CITY OF ALBUQUERQUE

May 22, 2017

**RE: Paseo Marketplace
Conceptual Grading Plan
Revision Stamp Date: 5/17/17
Hydrology File: D18D056**

**C-1**

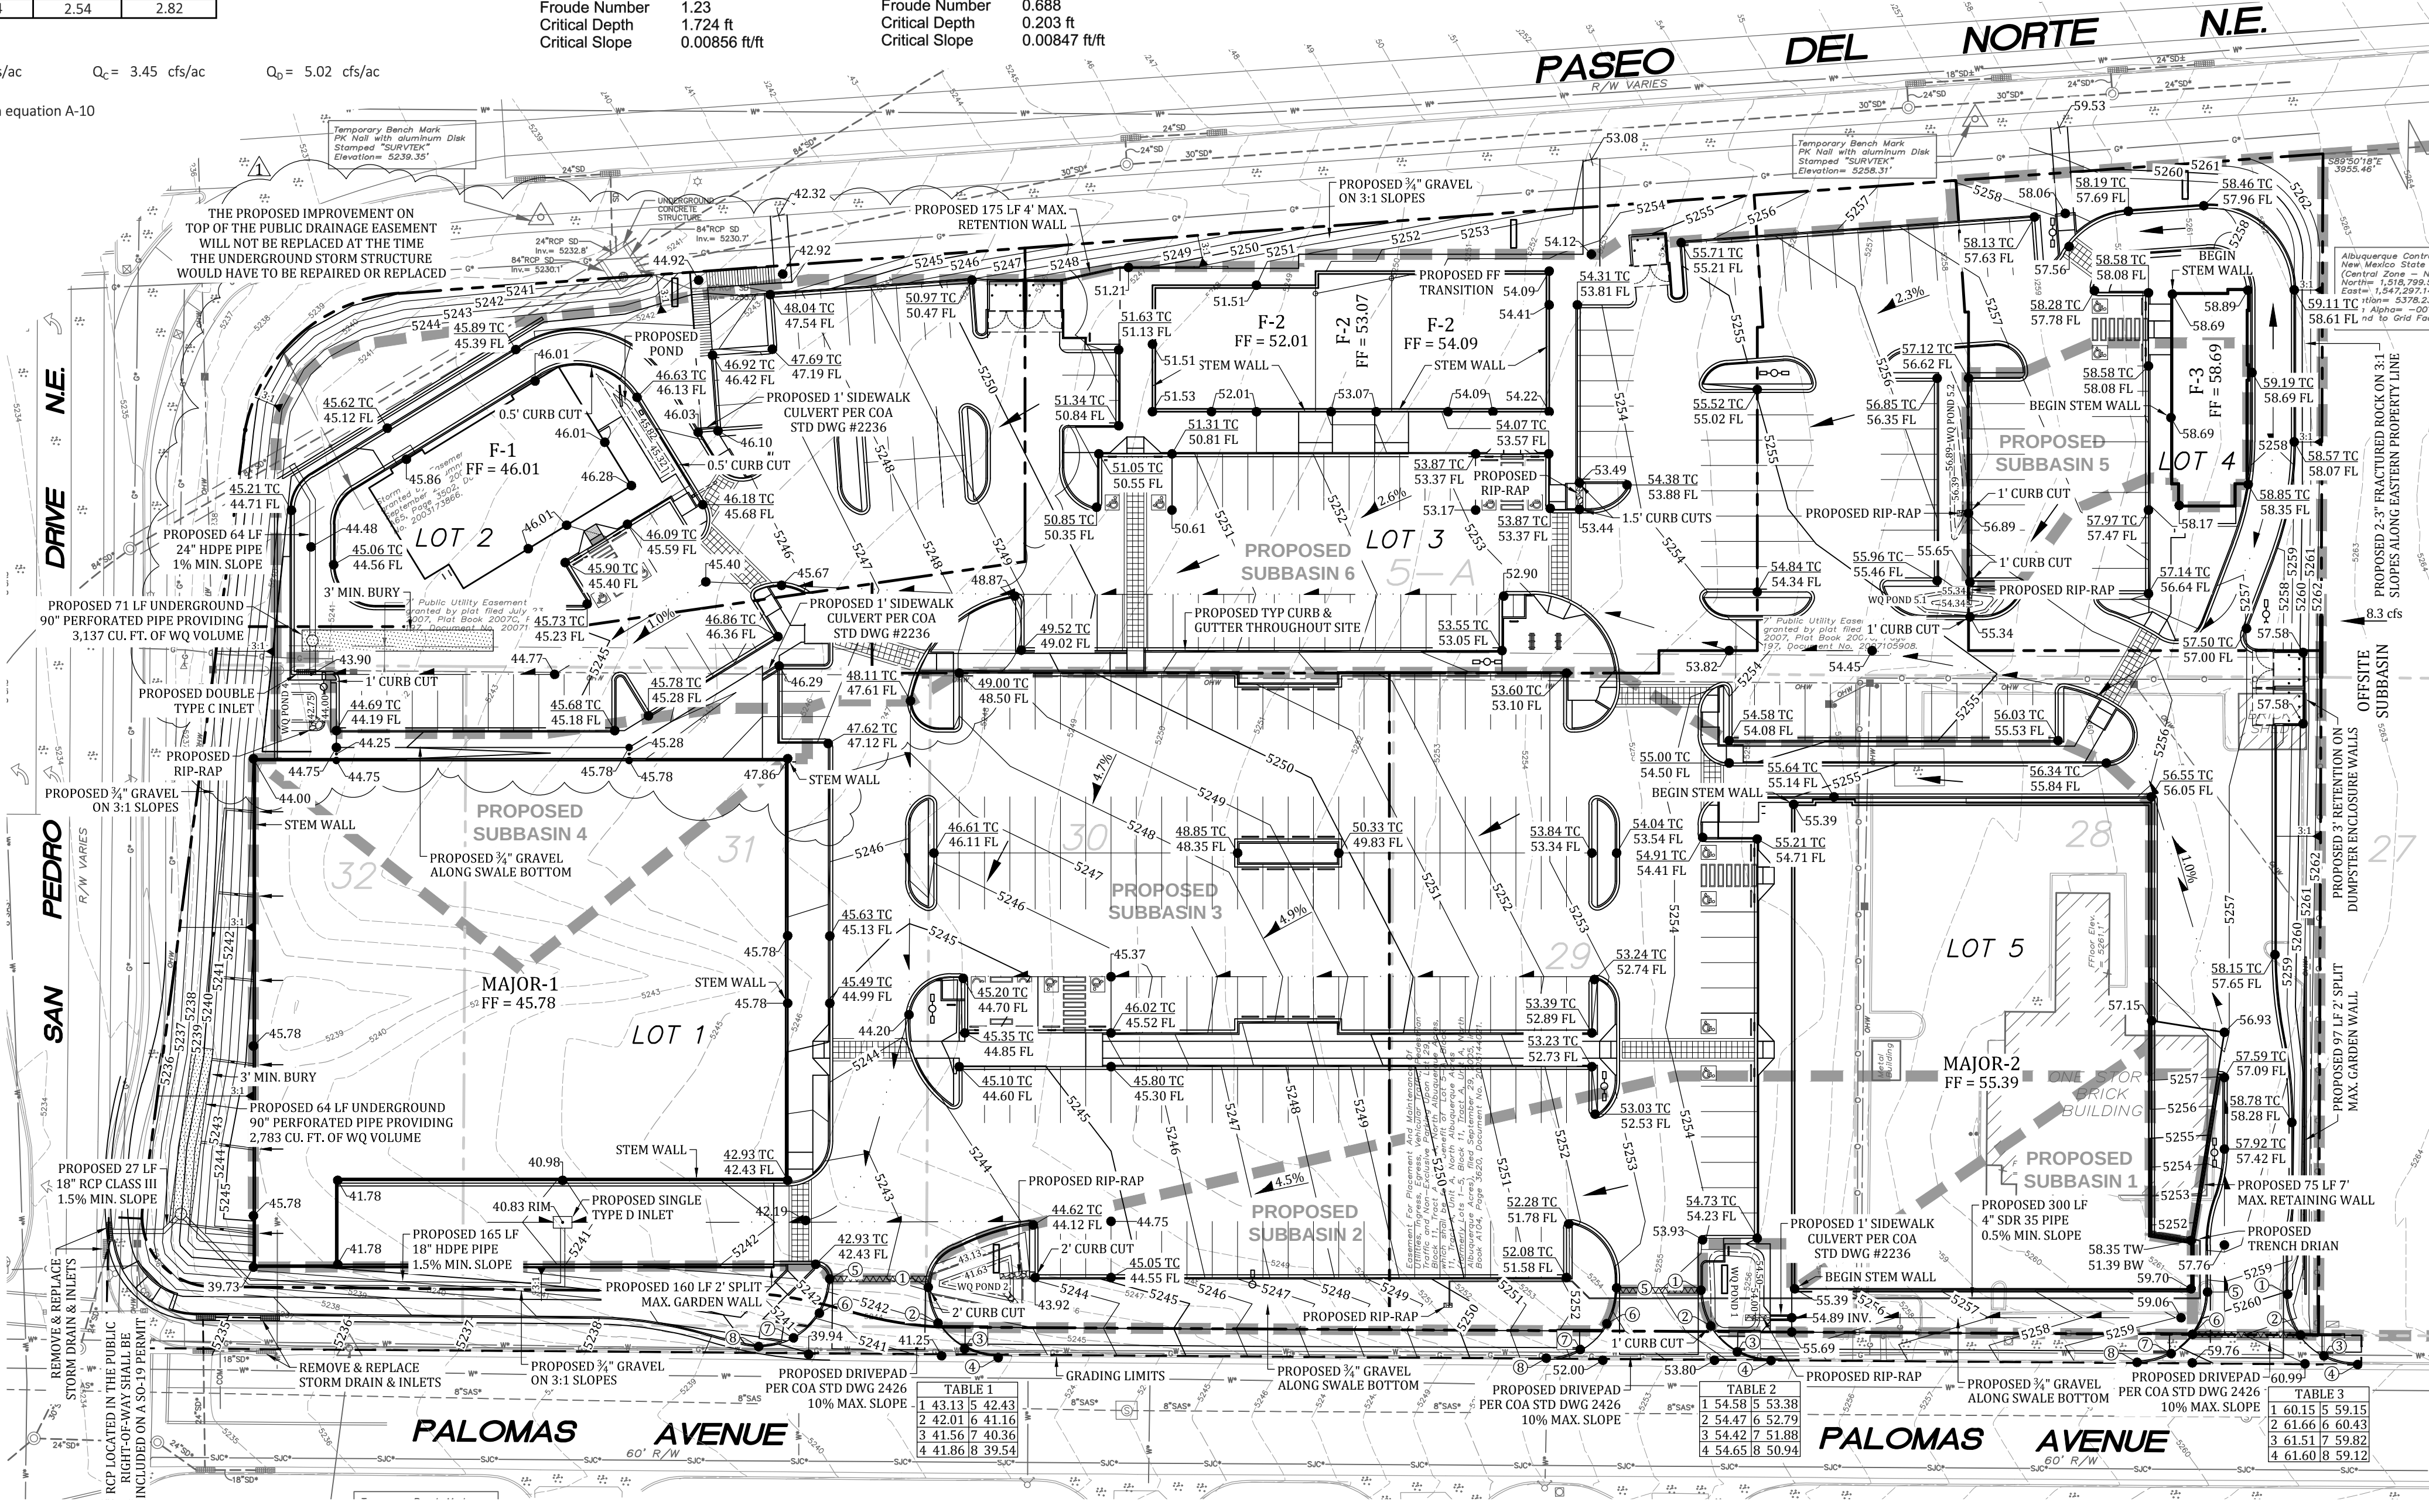
1. Please provide the calculation for the 100 year HGL through the proposed storm system. Starting at the existing 84" pipe and ending at the proposed double Type D inlet and from the proposed 30" pipe and ending at the proposed single Type D inlet.
2. Please provide profiles of the proposed storm system. One from the existing 84" pipe through the proposed 30" pipe to the proposed double Type D inlet (Subbasin 6). The other one from the proposed 30" tee through the proposed 18" pipe through the proposed MH to the proposed single Type D inlet (Subbasin 3).

3. Please provide a detail for the connection to the existing 84" pipe.
4. Please provide a detail for the connection of the 90" perforated pipe and the double Type D inlet.
5. Please provide a detail for the connection of the 90" perforated pipe and the MH.
6. Please provide a bedding detail of the 90" perforated pipe.
